OAKLANDS FARM SOLAR PARK

Non-Material Change Supporting Statement (EIA Addendum)

Document Ref: EN010122/NMC/1.1

Planning Inspectorate Reference	EN010122
Document Reference	EN010122/NMC/6.1
Author	Oaklands Farm Solar Limited

Works No. 4
Works No. 4a
Works No. 4b
Works No. 6
Works No. 8

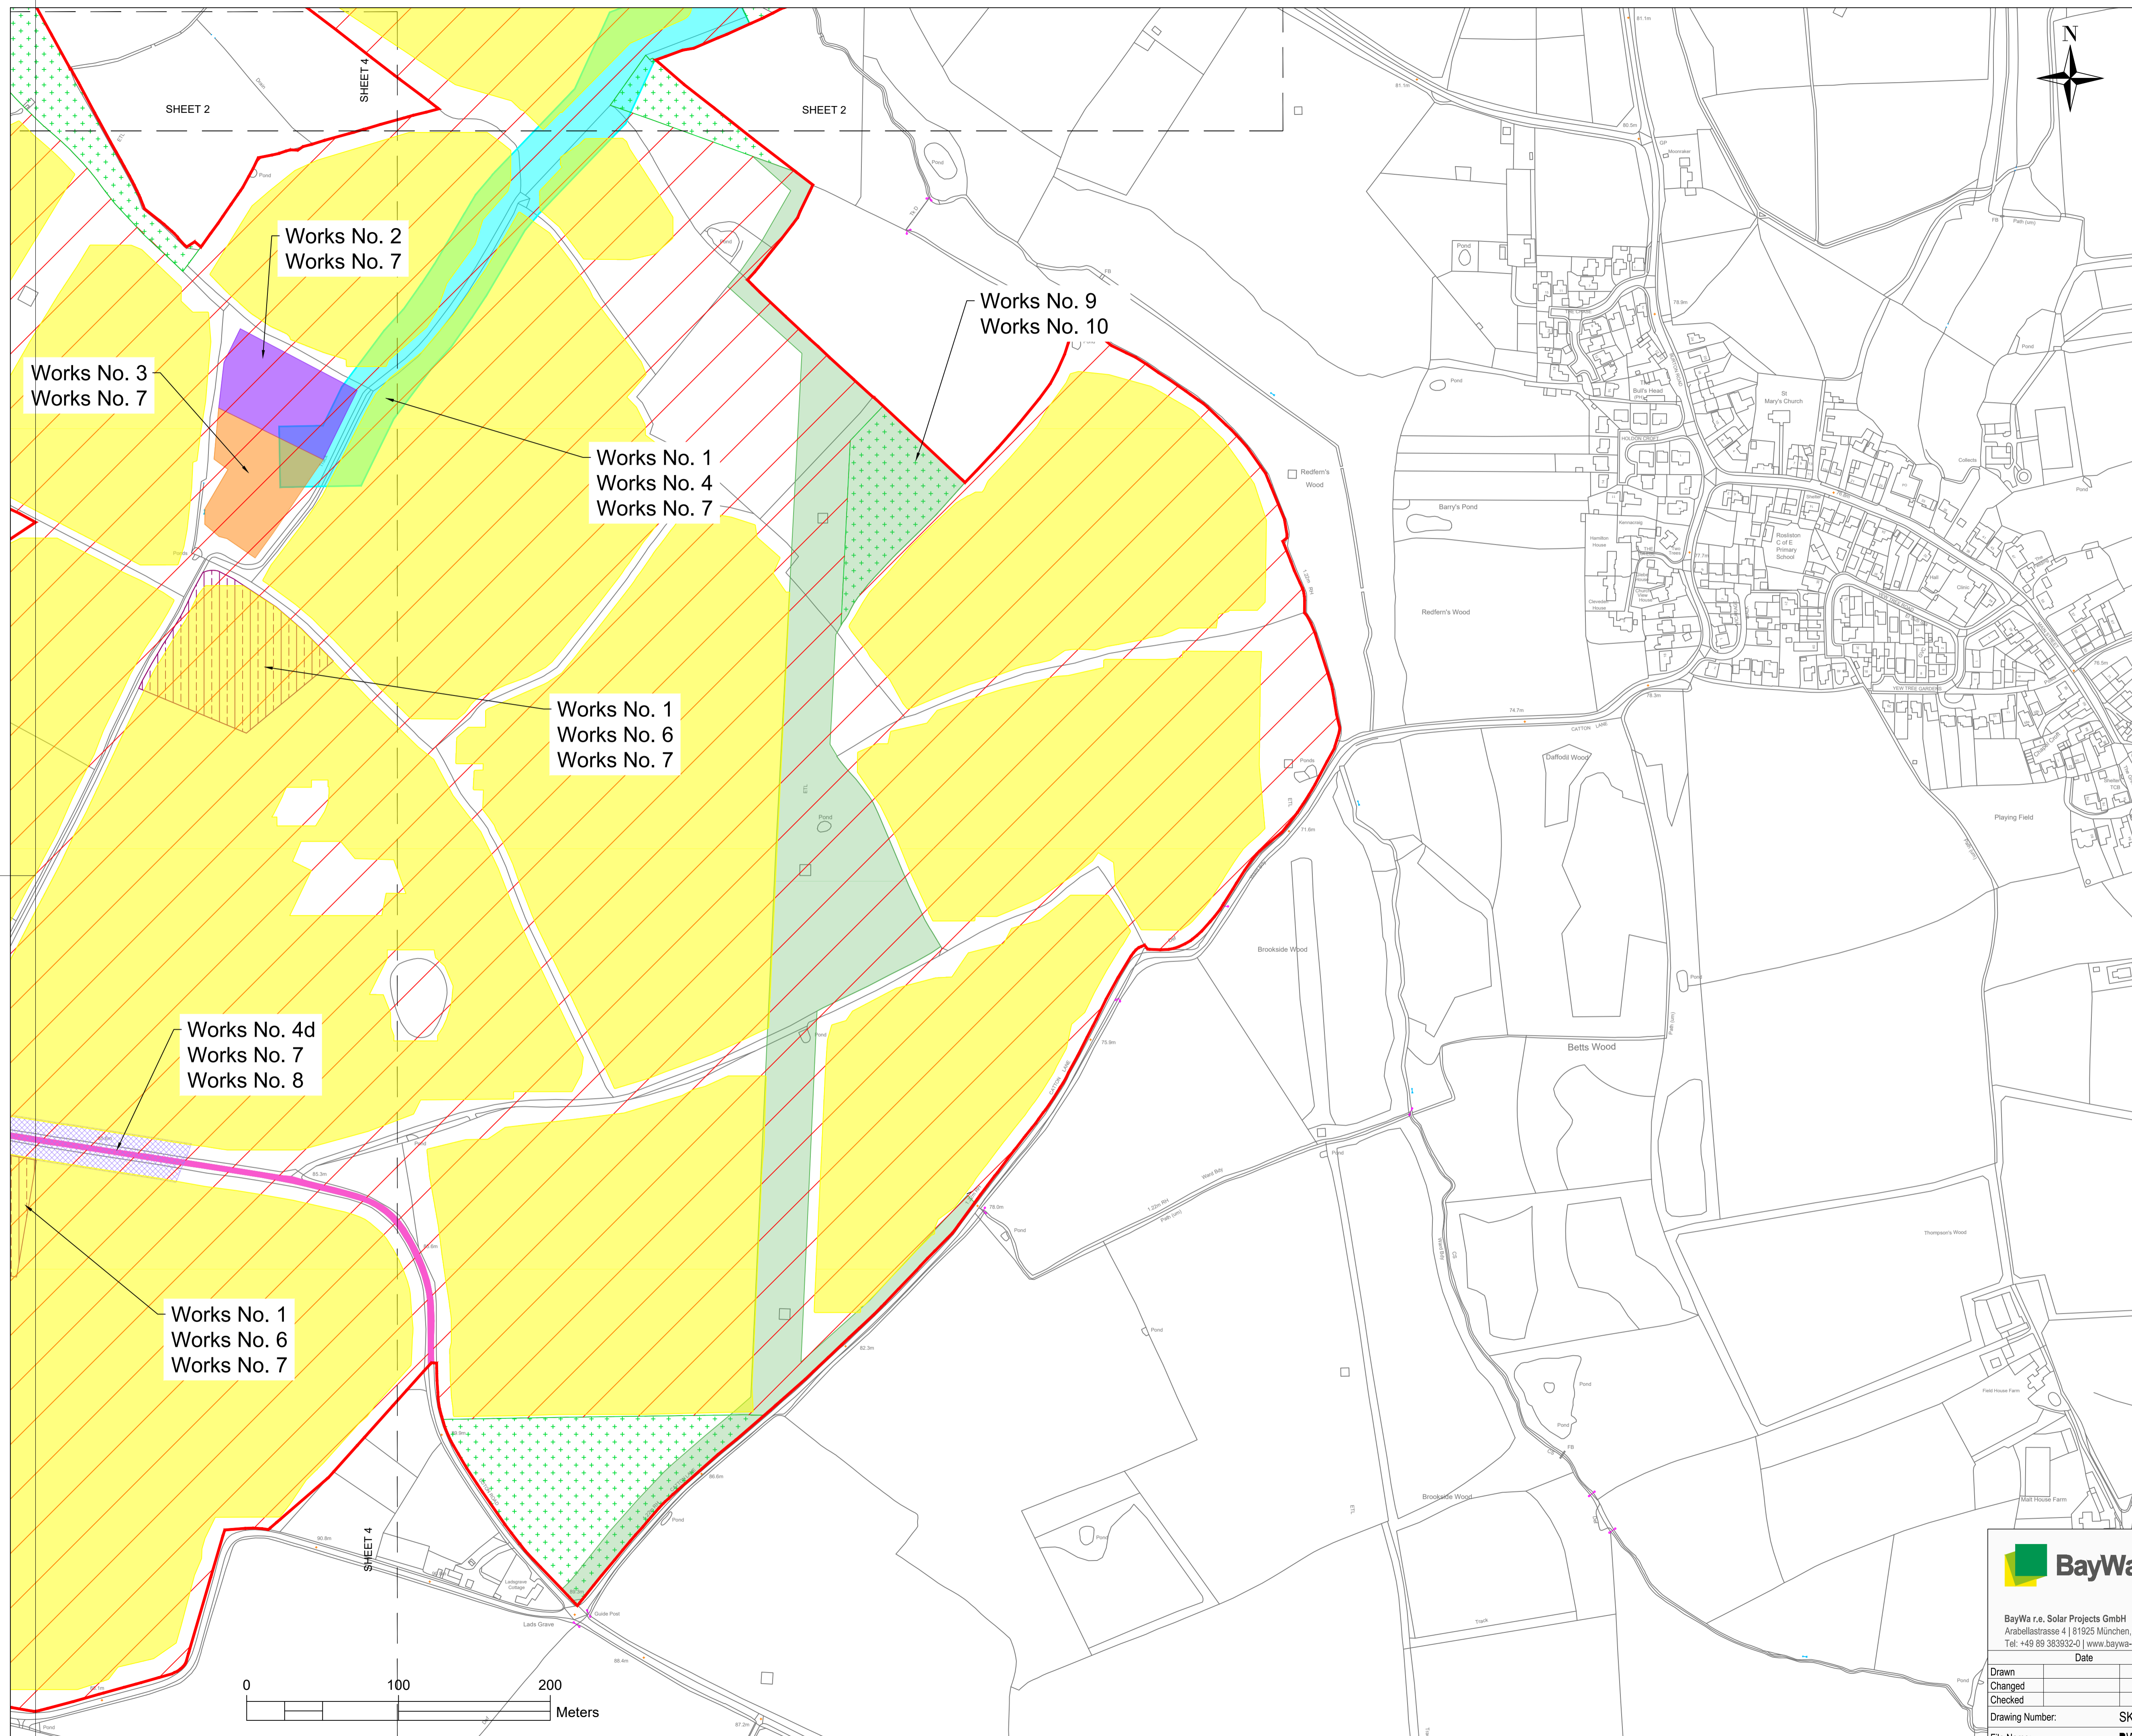
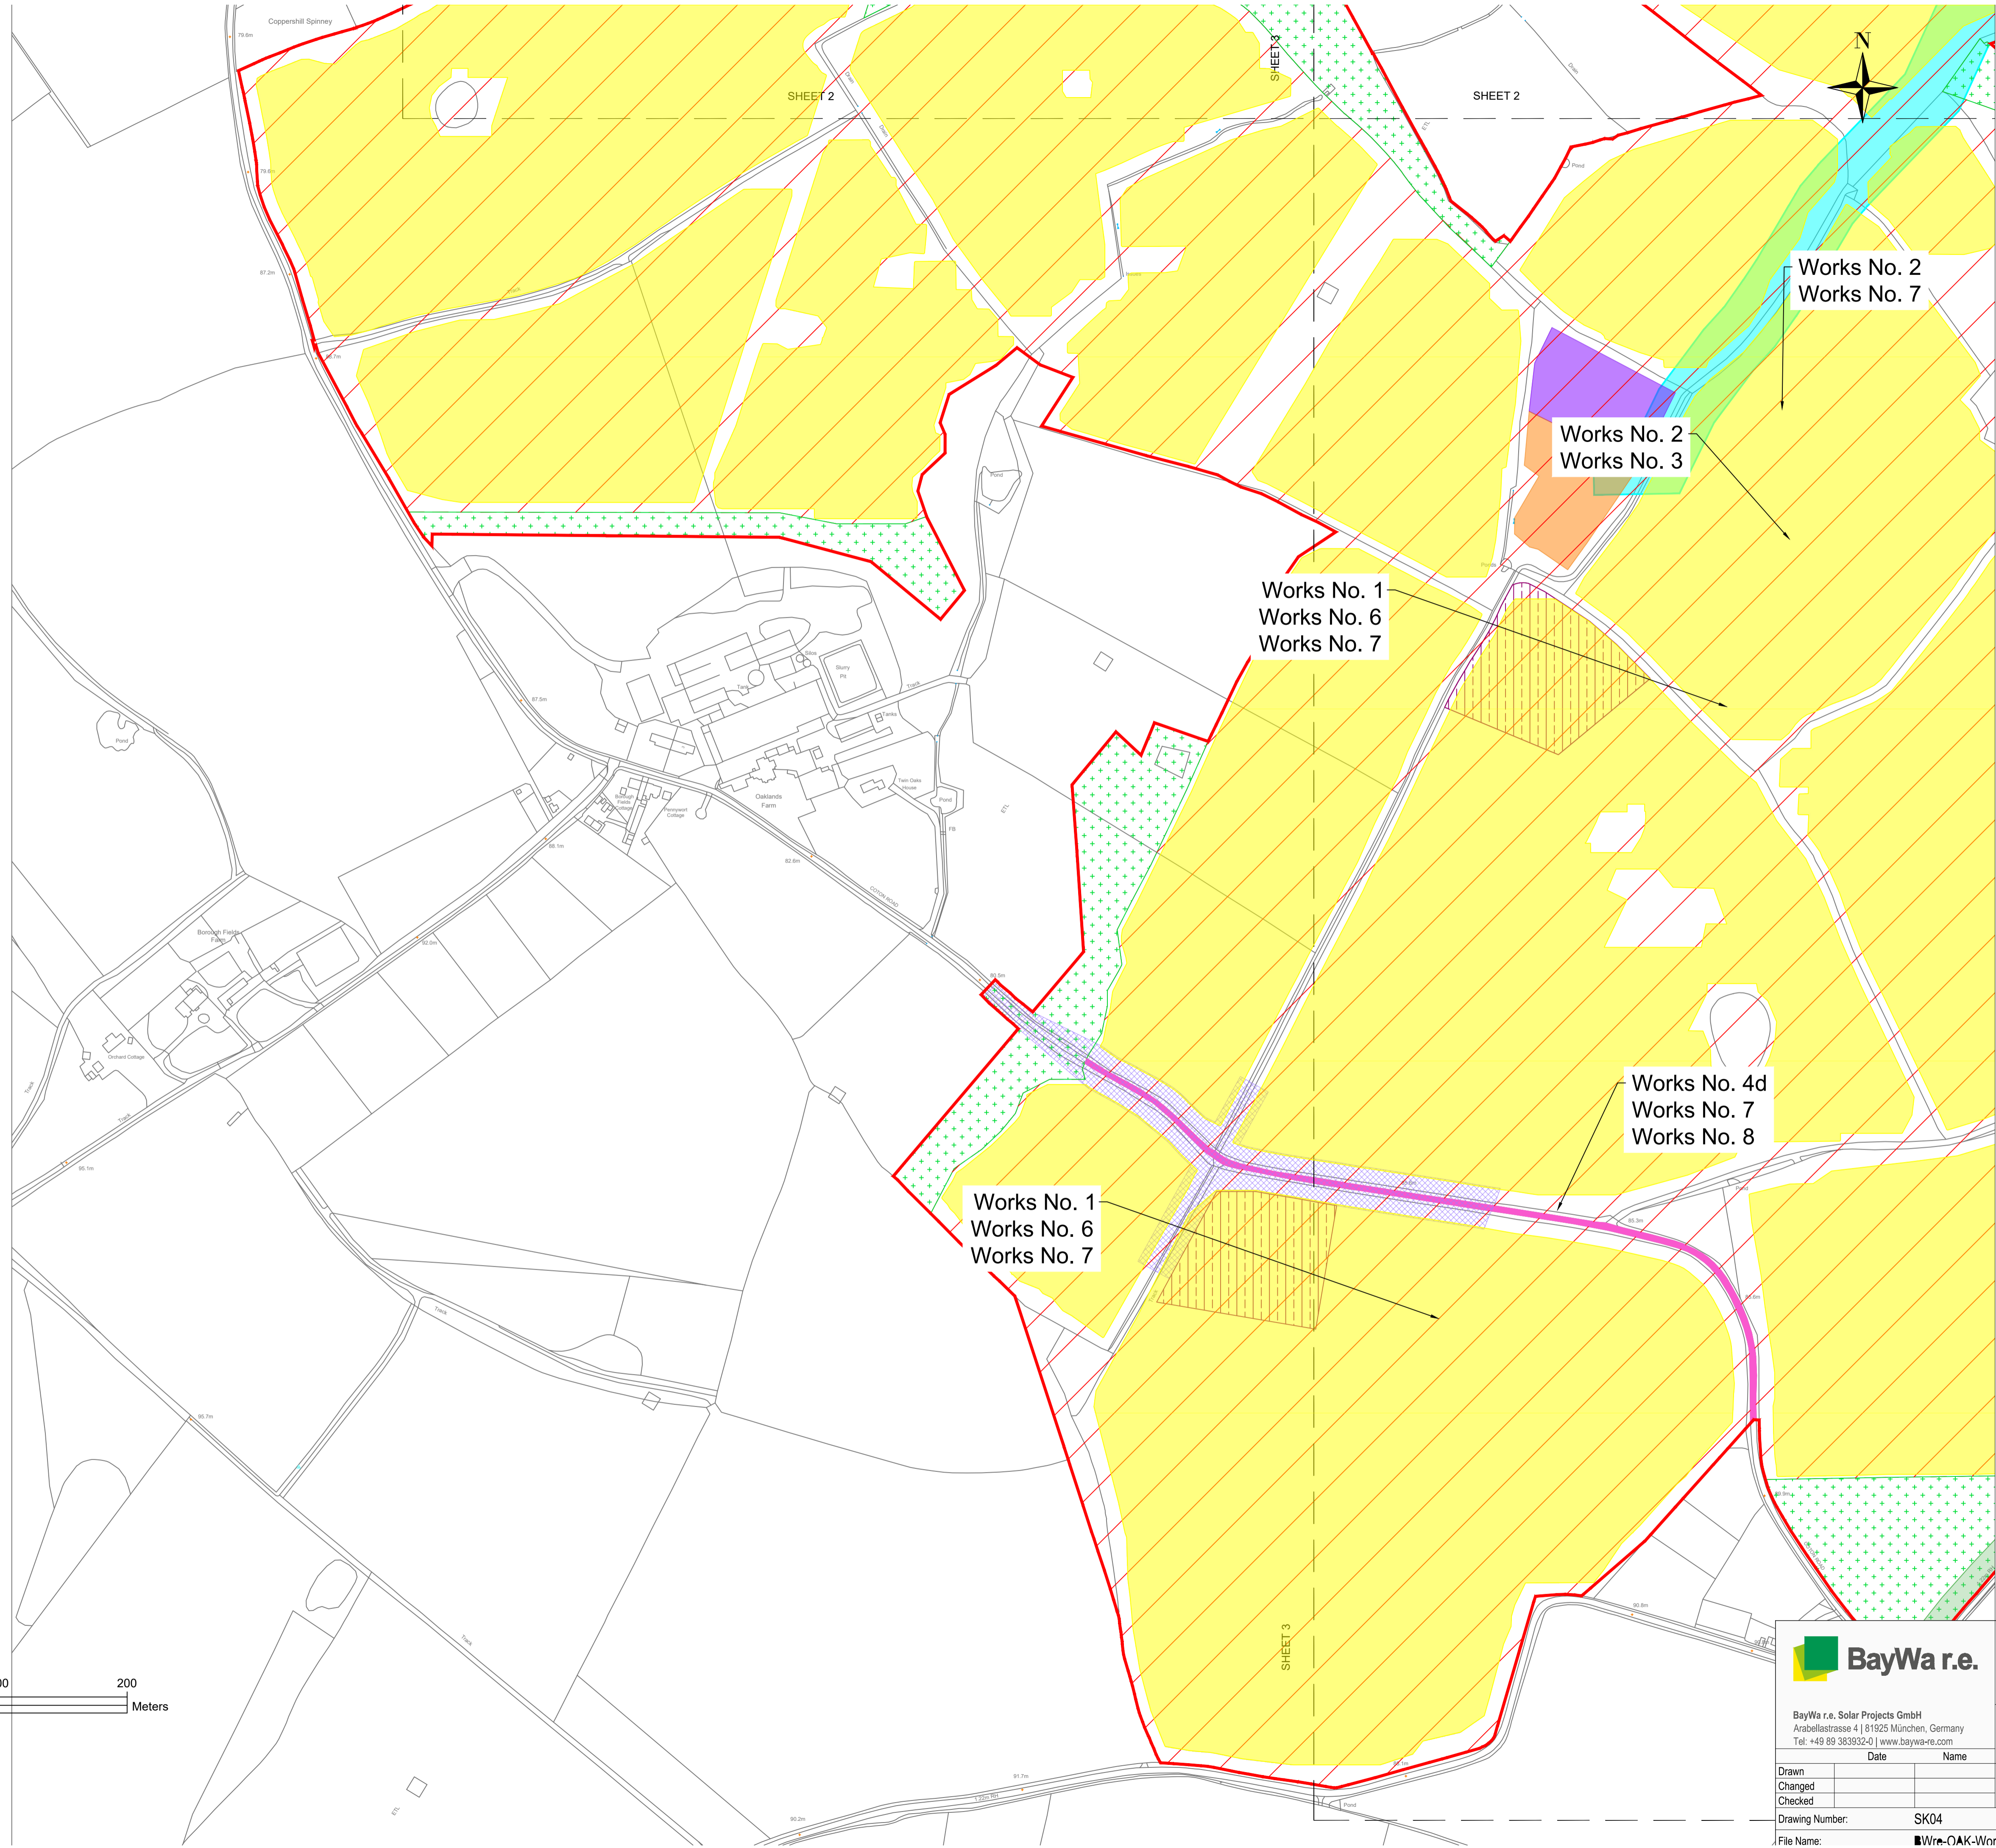
- 3.2.1 Through detailed procurement and design processes, the Applicant has been able to optimise the design by using newer technology. This primarily means the available land can be more effectively utilised to lay out the equipment to maximise efficiency and solar capacity. For example, more powerful inverter units can individually support a greater number of solar panel tables, and therefore more configurations of panel rows are possible to fit into irregularly shaped fields. Similarly, higher output solar panels mean the solar panel tables can be longer and therefore deployed more effectively in awkwardly shaped areas. To realise these optimisations, the Applicant proposes to slightly expand the footprint of work no. 1 in specific areas as shown in Appendix A and the revised Work Plans (Ref: EN010122/NMC/2.3). In addition, through the detailed design process the Applicant has identified three small areas which can be removed from the work no. 1 parameter area comprising the entirety of field 010, part of field 020 and a small area in field 04. This is because it is impractical to install solar panels in these areas due to the topography. The new amended area for work no. 1 along with an indicative solar panel layout is provided at Appendix A.

- 3.2.2 A Comparison Plan between the existing work no. 1 area and the proposed work no. 1 area is attached at Appendix B which highlights where the areas of work no. 1 have been extended and removed. This clearly shows that the proposed expansion accords with the general footprint of the Proposed Development. The Applicant considers the extensions are minimal, resulting in an overall increase of only 3.4% in the parameter area of work no. 1. Therefore, this change is non-material.

- 3.2.3 The revised Works Plan (ref. EN010122/NMC/2.3) captures the amendments to the parameter area of work no. 1.
